Castlelake SHD,
Carrigtwohill, Co. Cork

Quality Audit

Document Ref:	P22-040-UQA-GEN-RP-001
----------------------	-------------------------------

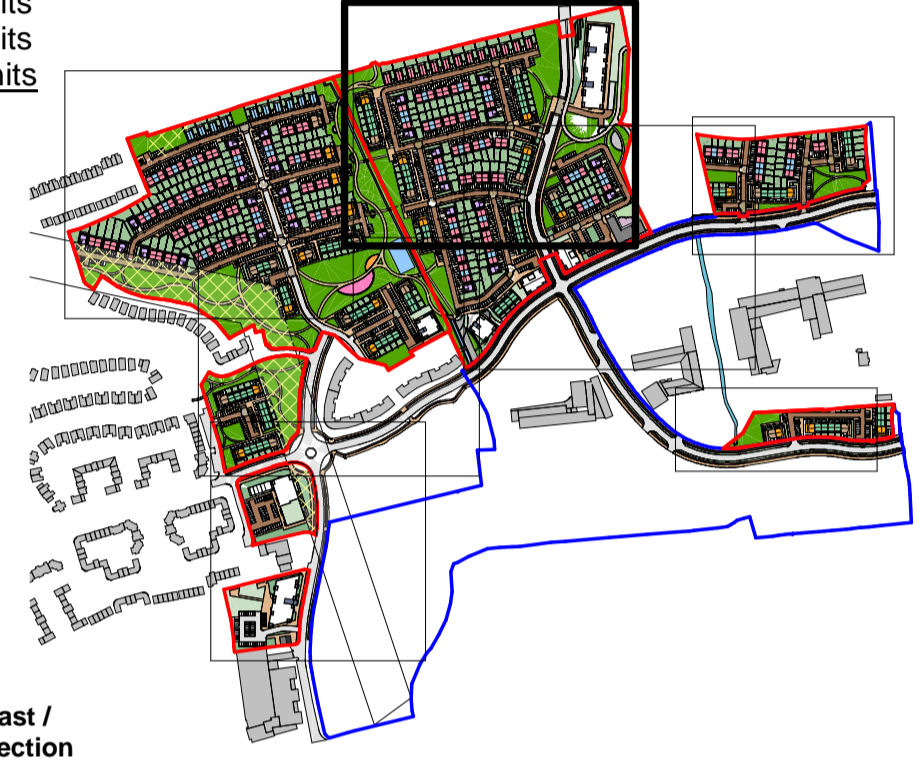
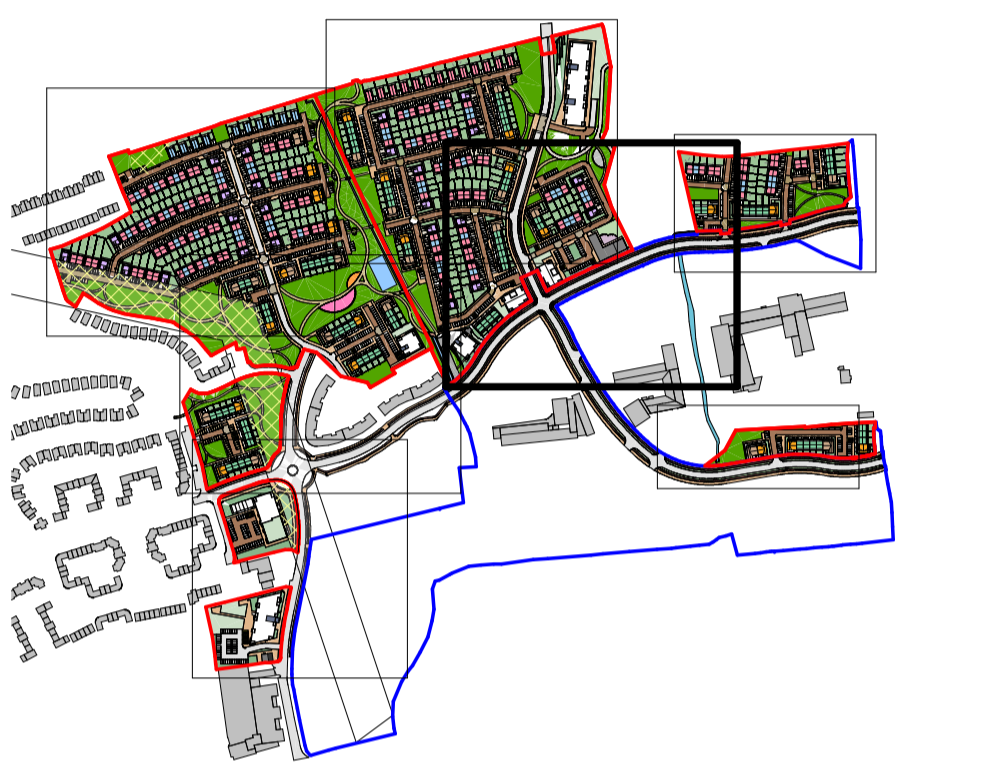
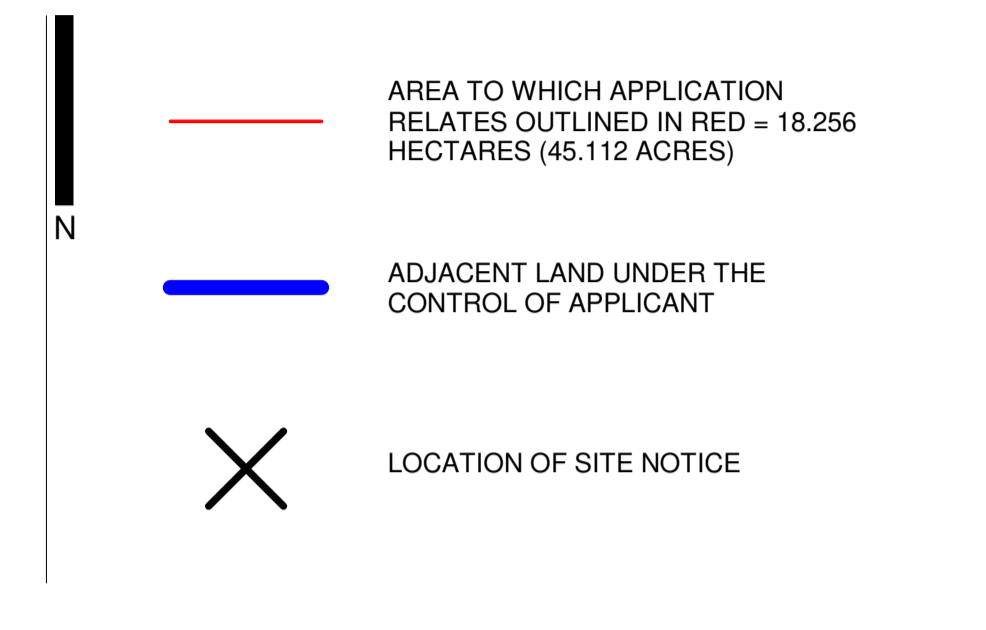
Summary: Junction control, or priority, has not been indicated at the junctions within the proposed development sites.

The junction control (stop, yield etc.), and thus priority, at the development's internal junctions has not been indicated. The absence of adequate road markings and signage may lead to driver confusion and hesitation resulting in drivers misinterpreting priority at the junction and entering the junction at the same time as opposing vehicles where there is an increased risk of side-swipe or side-on collisions.

Summary: The swept path of vehicles has not been provided. It is therefore unclear if all vehicles can safely turn within the development.

Details regarding the swept path of vehicles has not been provided to the Audit Team. It is therefore unclear if all vehicles can safely turn within the development.

Also, perpendicular parking is provided on Blandcrest Street 08, however no protection is provided to the southernmost parking spaces. Turning traffic may strike or collide with exposed vehicles parked the southernmost space, leading to material damage and personal injury collisions.

Summary: It is unclear if the proposed development will be sufficiently lit during the hours of darkness.

Information regarding public lighting within the proposed development has not been provided to the Audit Team and it is therefore unclear if the development will be sufficiently lit during the hours of darkness.

Summary: Tactile paving has not been indicated at the transitions between shared surfaces and segregated footways.

Tactile paving (e.g. ladder and tram) has not been indicated at the start and end of shared and segregated surfaces. This could lead to visually impaired pedestrians inadvertently entering the cycle track, or approaching shared surfaces and being unaware of the presence of cyclists, which may increase the risk of pedestrian-cyclist collisions.

Also, it is unclear how cyclists are to safely transition to the carriageway at the end of the cycle track. Drivers may be less attentive to a cyclist entering the carriageway from a raised cycle track resulting in an increased risk of vehicle-cyclist collisions.

Summary: Absence of dropped kerbs and tactile paving at the mobility impaired parking spaces.

Mobility impaired parking spaces have been indicated throughout the development. It is unclear from the information provided if dropped kerbs and associated tactile paving are proposed at each Mobility impaired parking space. The absence of dropped kerbs could lead to difficulties for mobility impaired road users in accessing the footpath once they leave their vehicle, and force users to travel long distances within the carriageway until a dropped crossing is found, which may increase the risk of vehicle/pedestrian collisions.

Summary: It is unclear if there is sufficient space for vehicles to safely exit all parking spaces within the development.

Drivers may be unable to safely exit parking spaces located at the extents of the carpark, where they are in areas constrained by adjacent parking spaces, building structures, or kerbs. The constrained nature of these parking spaces may lead to material damage collisions.

Summary: Unclear if there is sufficient space for vehicles to safely perform a u-turn manoeuvre when exiting the internal street.

Mobility impaired parking spaces are located at the end of Blandcrest Street 01 and Station Road Street 03. Given the local constraints at each parking space, users within the Mobility impaired parking spaces may be required to reverse long distances to exit the street. This may increase the risk of material damage and vehicle/pedestrian collisions.

Summary: Failure to provide VRU facilities on all pedestrian desire lines may lead to slips, trips, and falls.

The development proposes uncontrolled pedestrian crossing points (i.e. tactile paving) in certain locations, but not all pedestrian desire lines have been accommodated within the scheme extents. No facilities have been provided between the existing public open space and the surrounding residential developments, for example across Castlelake Avenue or Castlelake Main Road. Failure to provide an appropriate facility for non-motorised users at these expected desire line could result in unsafe

Summary: Proposed structures over the open drainage channel may restrict inter-visibility between drivers and crossing pedestrians/cyclists.

Two new accesses are proposed across an existing open drainage channel at the development's north-eastern extents. The accesses will need to span the open drainage channel, so may include a parapet and handrailing to prevent users from falling into the channel. The provision of a parapet and handrailing may limit inter-visibility between drivers existing Station Road Streets 02 & 03 and pedestrians/cyclists on the footway, leading to possible vehicle/pedestrians and vehicle/cyclist collisions.

Summary: Lack of a pedestrian link between the footpaths may lead to pedestrians creating an informal pathway through the grass verge, leading to slips, trips, and falls.

Pedestrian links between footpaths have not been indicated at two locations (Apartment Block 7 and the Station Road North site). Where footways are not provided, pedestrians may likely continue along the shortest route to their destination, which may result in the creation of informal walking paths through the grass verge. These informal paths may deteriorate over time, leading to slips, trips, and falls.

Summary: Inset mobility impaired parking spaces reduce the effective width of the footway.

Inset mobility impaired parking spaces are indicated at several locations within the development. These inset spaces reduce the effective width of the footway, and may force opposing pedestrians to step into the parking space, which may increase the risk of vehicle/pedestrian collisions.

Summary: The Apartment block 1 development access is in close proximity to an adjacent apartment block access onto Castlelake Avenue.

The development access for Apartment Block 1 is proposed in the northeast corner of the site. However, the proposed access is in close proximity to an existing development access to the north of the site. Proximity of the accesses could result in complicated interactions between the two accesses, driver uncertainty and confusion, as well as vehicles in adjacent accesses blocking each other's visibility. This may lead to side-on, material damage and personal injury collisions.

Ensure the junction control, and priority, at internal junctions between residential streets and main roads, and at crossroads, is clear via signage and road markings.

Ensure the swept path of large vehicles can be accommodated within the proposed development.

Also, modify the kerb line at the junction of Blandcrest Street 08 and Blandcrest Street 05 to ensure the southernmost parking space is protected by a kerb line.

Ensure the proposed development is sufficiently lit during the hours of darkness.

Tactile paving (e.g. ladder and tram) at the interfaces between shared and segregated surfaces should be provided.

Measures should be provided upstream of a junction to safely guide cyclists into the traffic lane. These measures should also include guidance for drivers such that they will be aware of the potential for cyclists to enter the traffic lane, and clearly advise of the priority between cyclists and motorised vehicles at the transition.

Provide dropped kerbs & tactile paving at mobility impaired parking spaces to permit safe access to/from the footways.

Swept path analysis should be undertaken within the internal carparks, and the layout adjusted where necessary.

The mobility impaired parking spaces should be reoriented to provide safe access and egress.

A thorough review of likely pedestrian desire lines should be undertaken, and tactile paving/dropped kerbs provided to facilitate safe VRU movement.

When developing the structural design at the two accesses, ensure sufficient inter-visibility is provided between drivers and pedestrians/cyclists. This may require a wider structure over the open channel at both locations.

Paved footpath links should be provided through the verge between the footpaths.

Ensure the effective width of the footpaths within the development are sufficient to accommodate the expected volume of pedestrians (in both directions) during peak times, particularly wheelchair users and parents with buggies.

The proposed development access to/from the Castlelake Avenue should be relocated, ensuring visibility requirements are met at the revised access.
